Re: Structural Observation — 2604 Holly Springs Church Road, Broadway, NC 27505

At your request, on September 19, 2022 we performed a visual structural observation of back addition at the Broadway residence noted above. The structure is a conventionally framed, detached, single family residence with raised first floor framing over a pier/girder foundation system with perimeter masonry foundation walls (*see picture 1*).

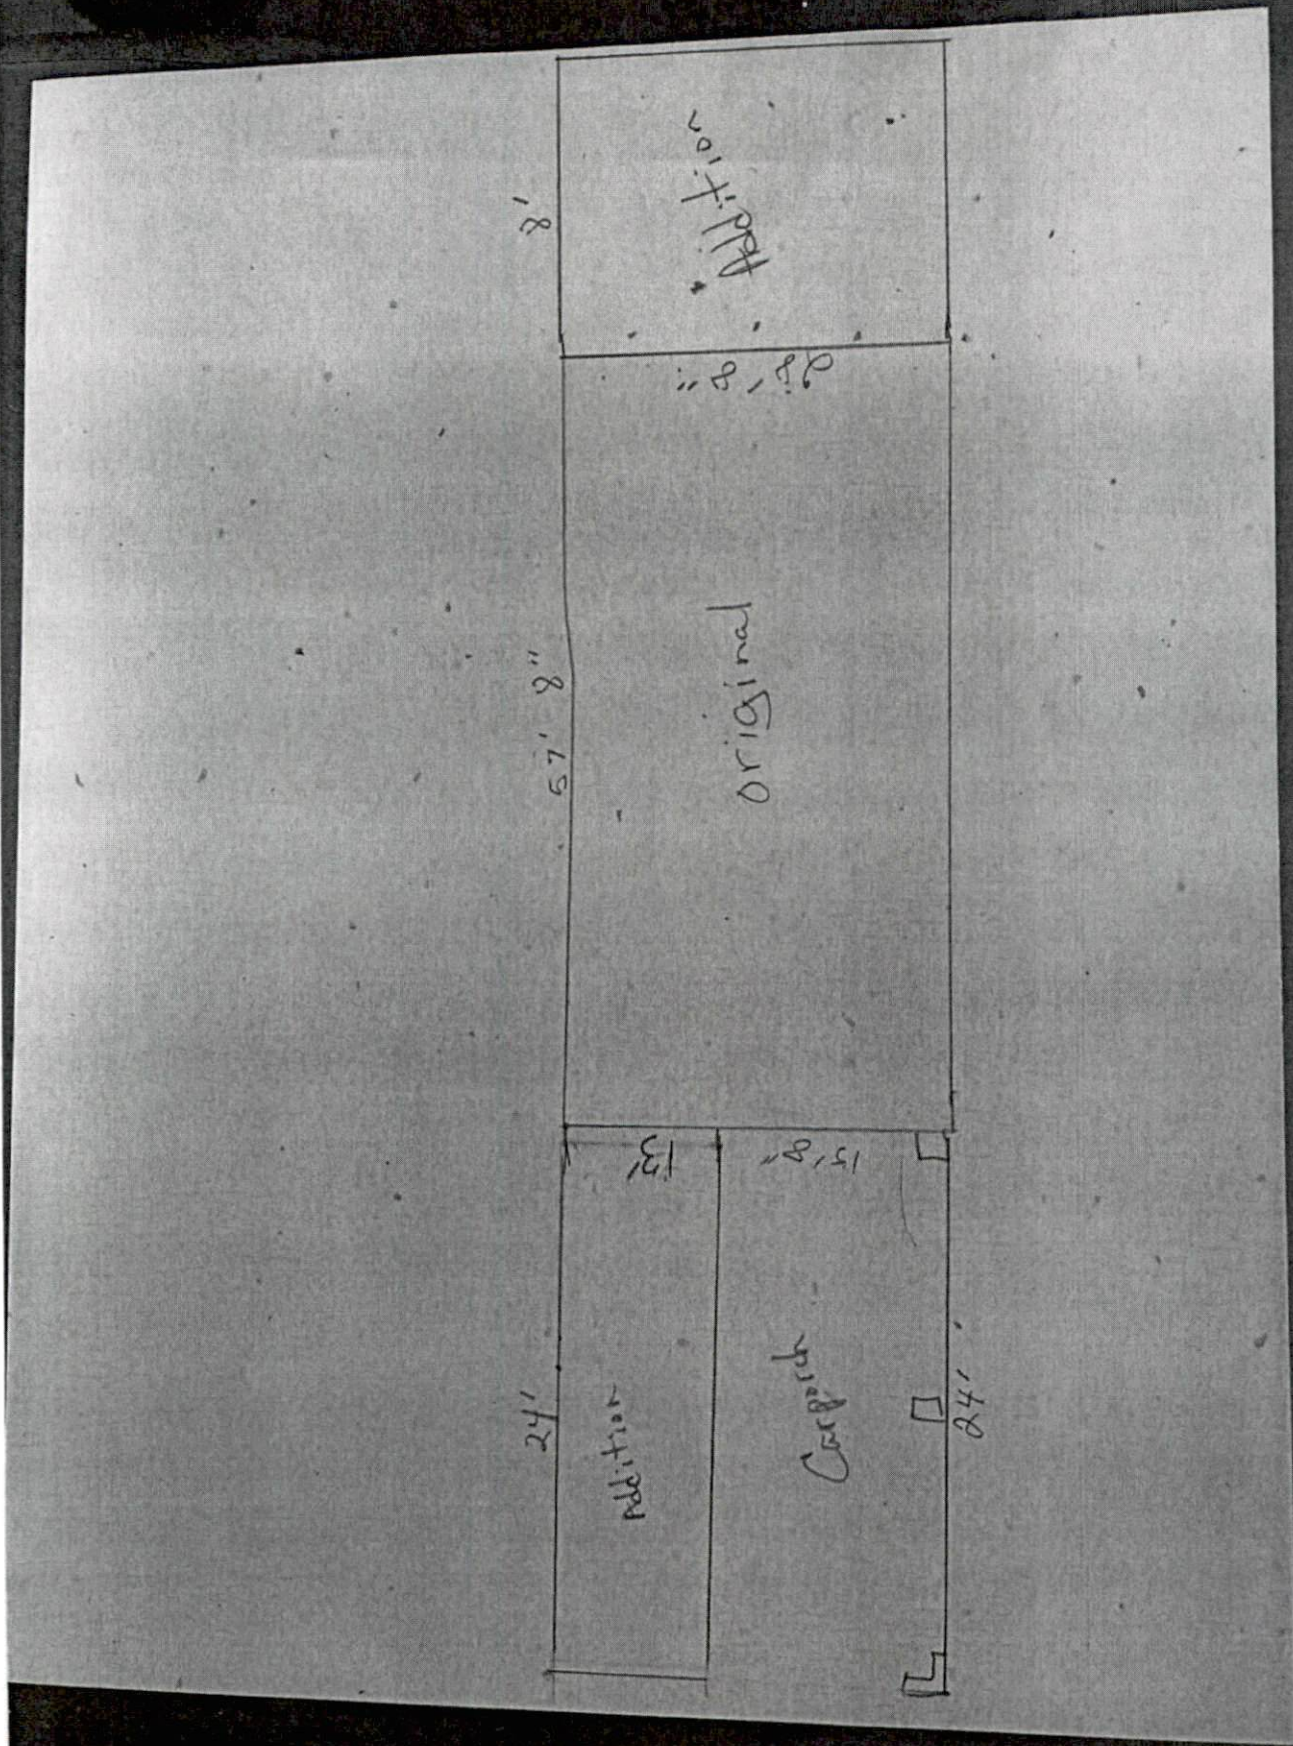
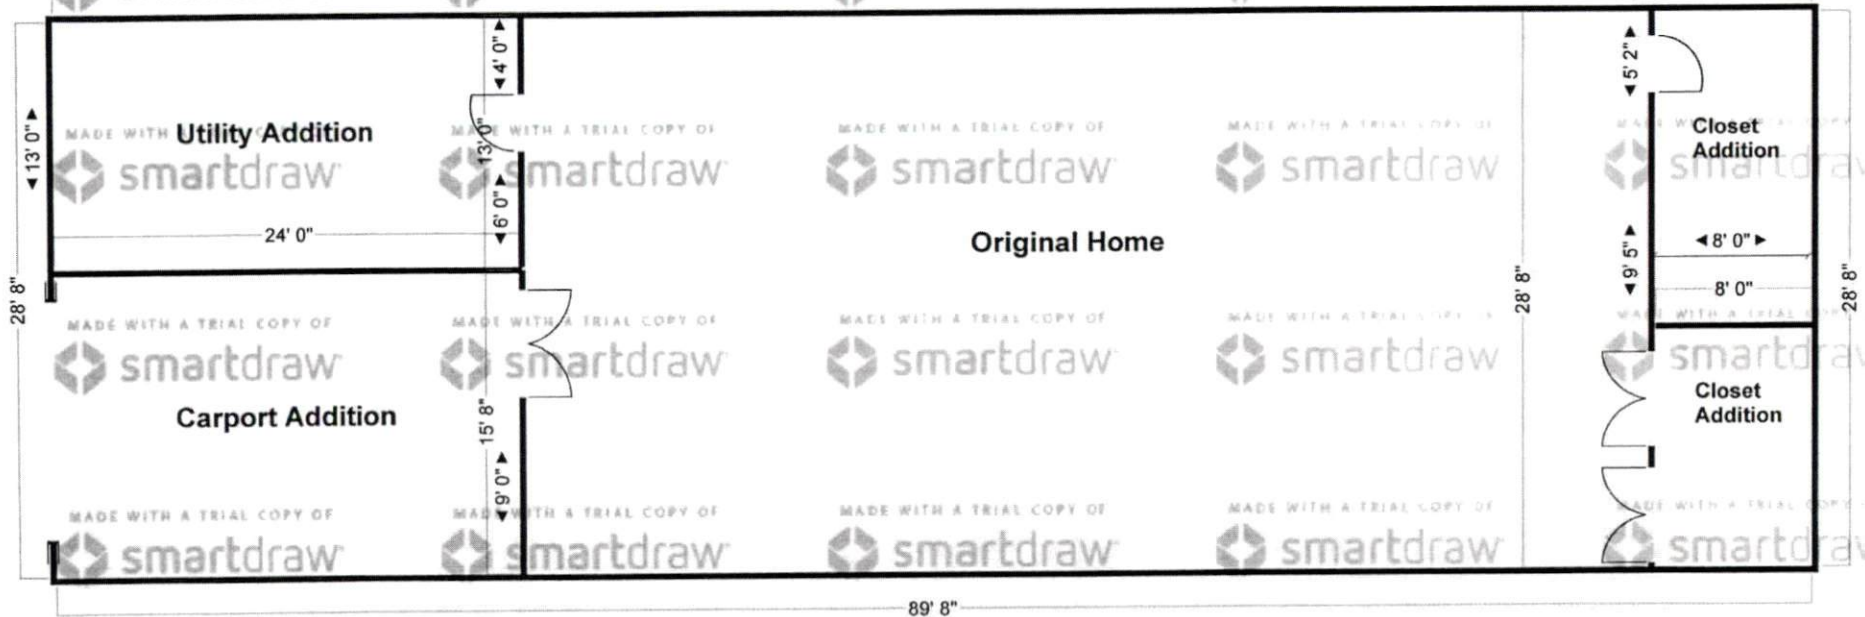
- The front ends of the trusses were supported by dropped beams. The sizes / material of the beams could not be determined due to the presence of finishes (*see picture 4 for example*).

- *Verify/provide that the front of the new roof trusses are supported by at least built-up (2)1¾”x11⅞” LVL (Boise Cascade VersaLam 3100 or equivalent) with continuous span between end supports.*

- *Verify/provide at least 4”x4” #2 SYP posts to support each of the ends of the beams.*
 - *The middle post should be centered over and conventionally fastened to a 26”x26”x10” thick poured concrete footing that is set at least 12” into suitable bearing soils.*

- *The left and right posts should be centered over and conventionally fastened to an 18”x18”x10” thick poured concrete footing that is set at least 12” into suitable bearing soils.*
